20 April 2022

Our Ref: R/2016/1/I
File No: 2022/239454
Your Ref: MP08_0098 MOD 17

Star Casino – Outdoor Gaming Area Conversion – MP08_0098 MOD 17 – Advice on Modification

Drawing Title
GA PLAN LEVEL 03

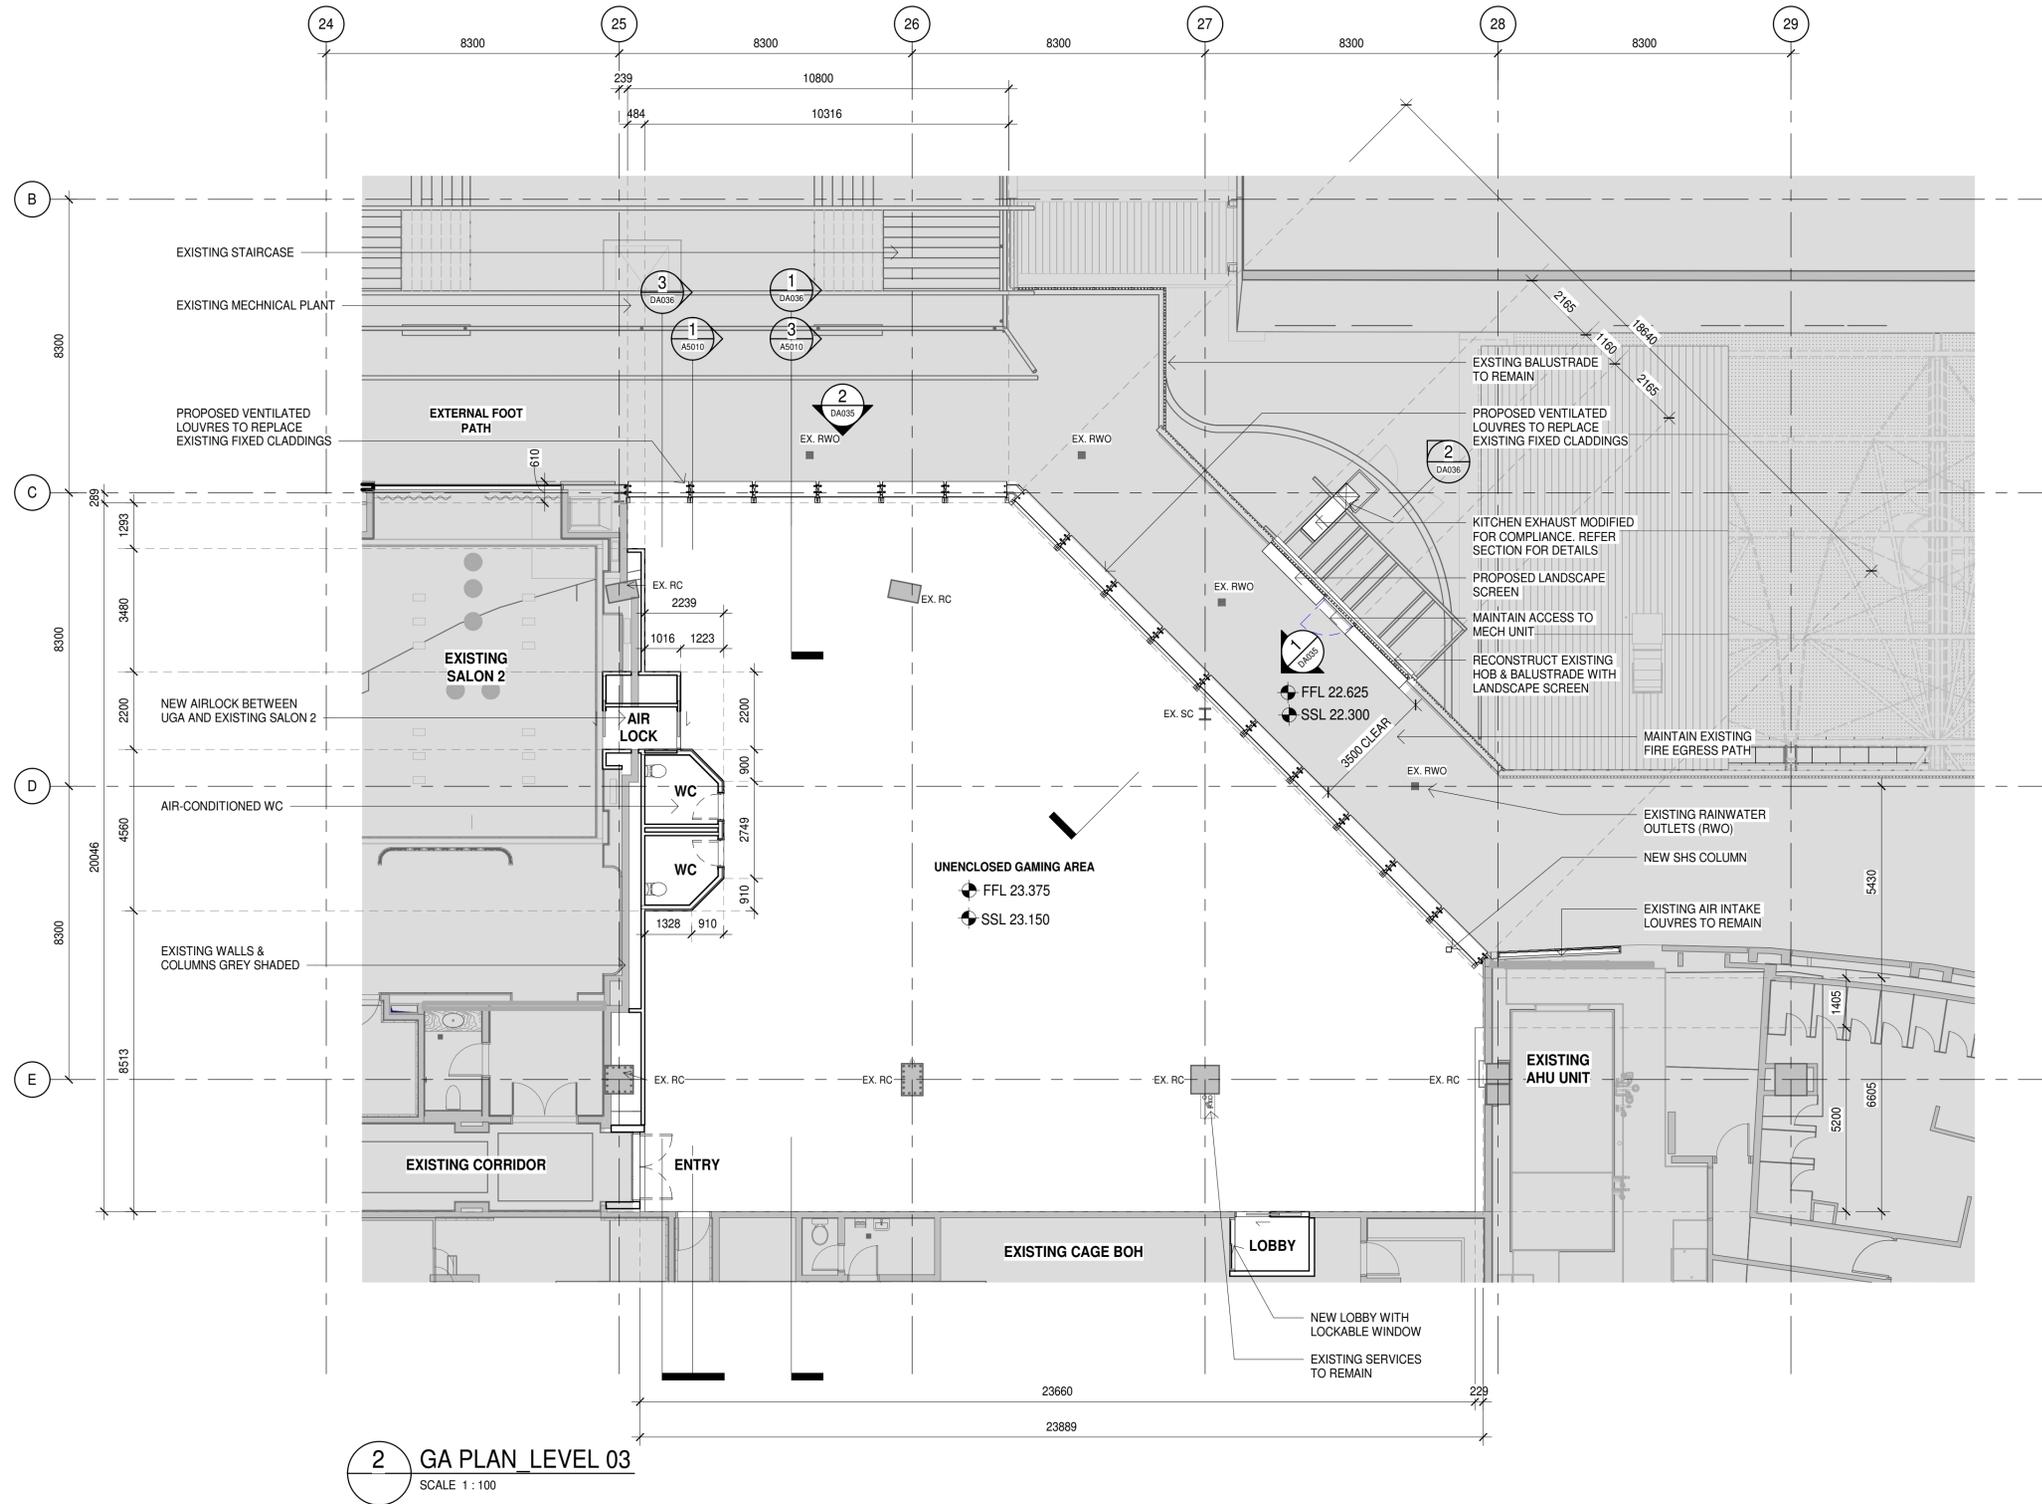
It is further noted that the drawings are unclear in areas and are difficult to follow. Plans should, at minimum, indicate where existing structures are being demolished or be accompanied by separate demolition plans.

Drawing Title
ELEVATIONS

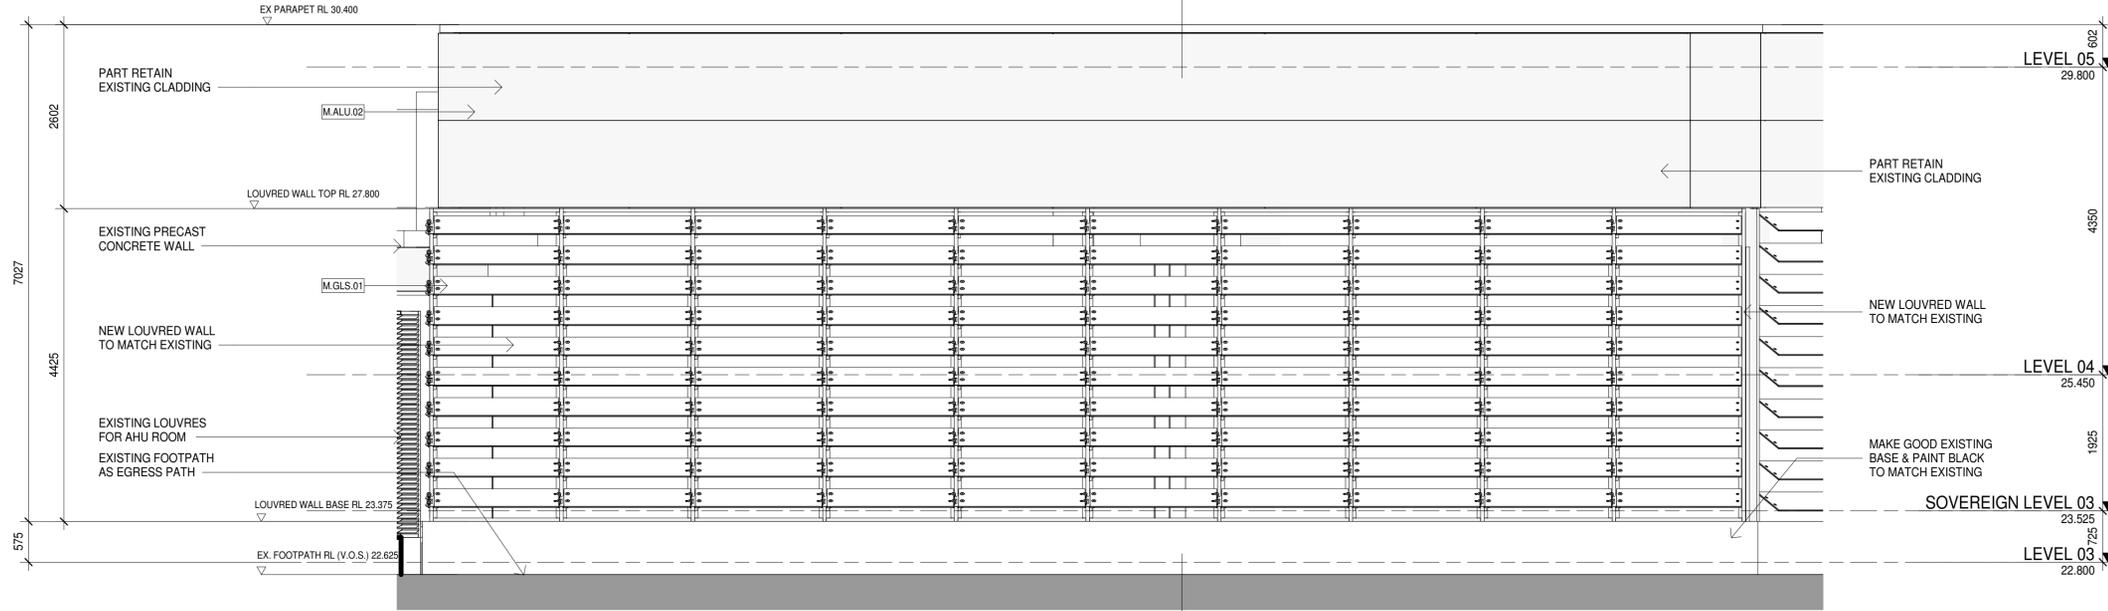
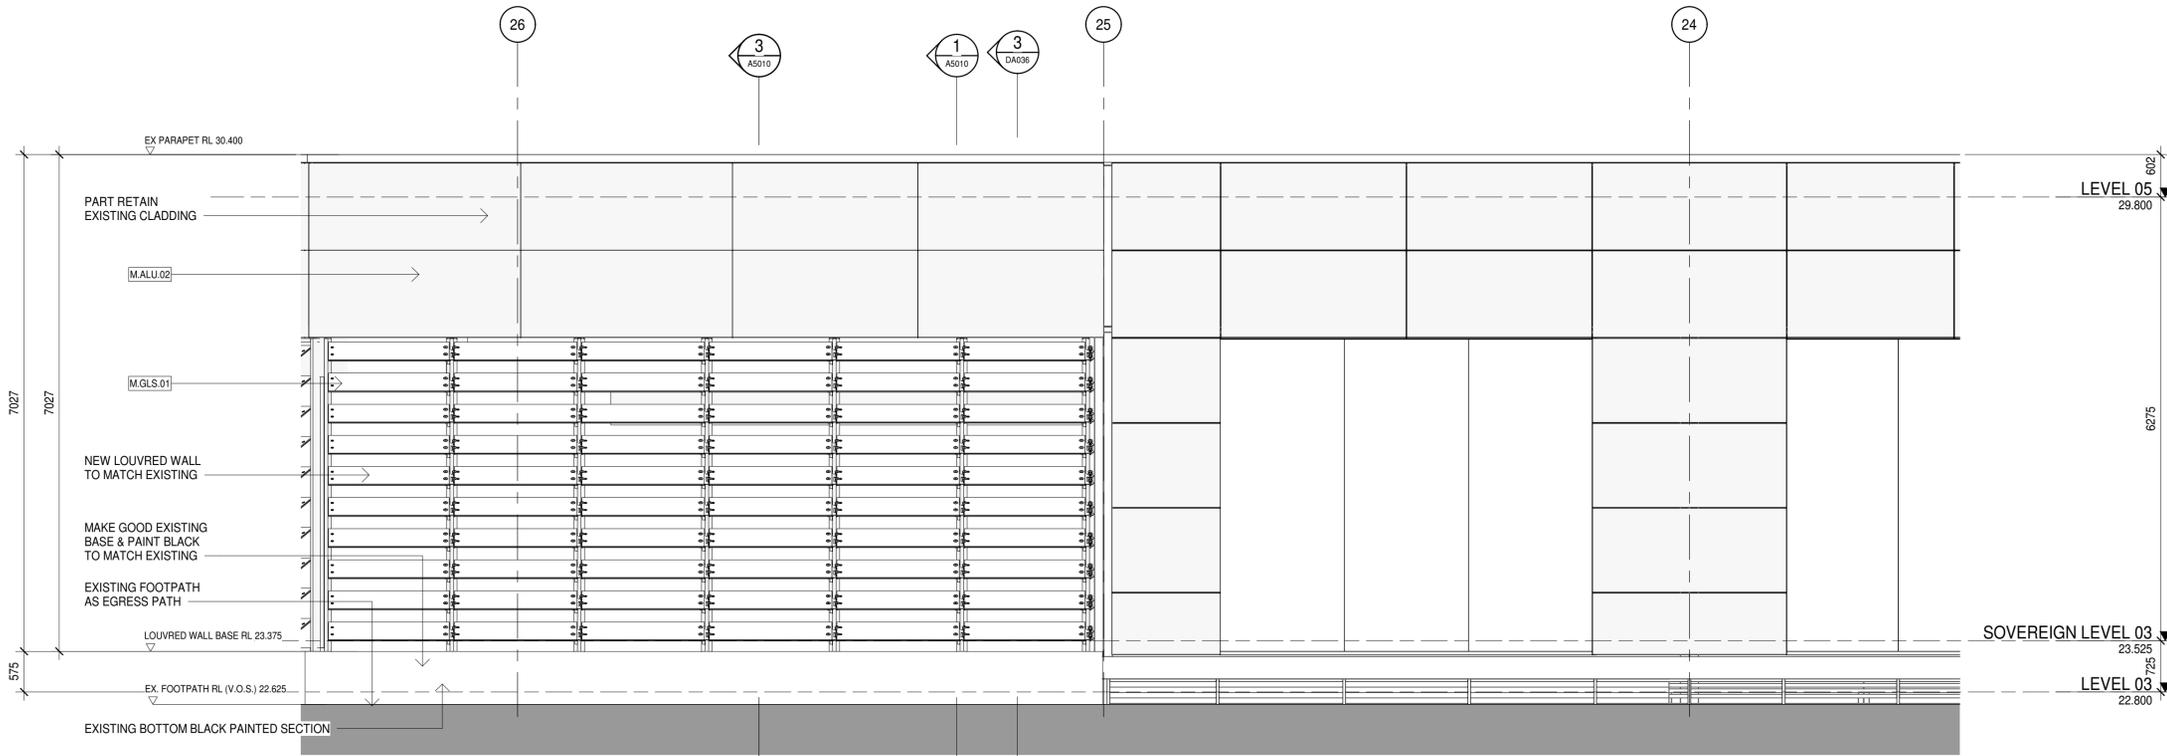
The City notes the proposed works convert internal gaming areas to unenclosed gaming areas located on Level 3. It is understood that the existing curved form will be partially demolished, and a new louvred wall will be constructed, disrupting the continuous curved wall fronting Pyrmont Street.

The curved form of the buildings within The Star precinct are a prominent design feature and any significant modifications to building form such as those proposed in this modification application should be avoided. It is recommended that any building modifications to convert internal gaming areas to outdoor gaming areas should occur within the existing footprint of the building, respecting the existing curved form of the building. Additionally, plans and supporting documentation should demonstrate that direct views to surrounding residential uses are mitigated, either with the provision of louvres fixed at an angle or closable louvres that have a restricted opening area.
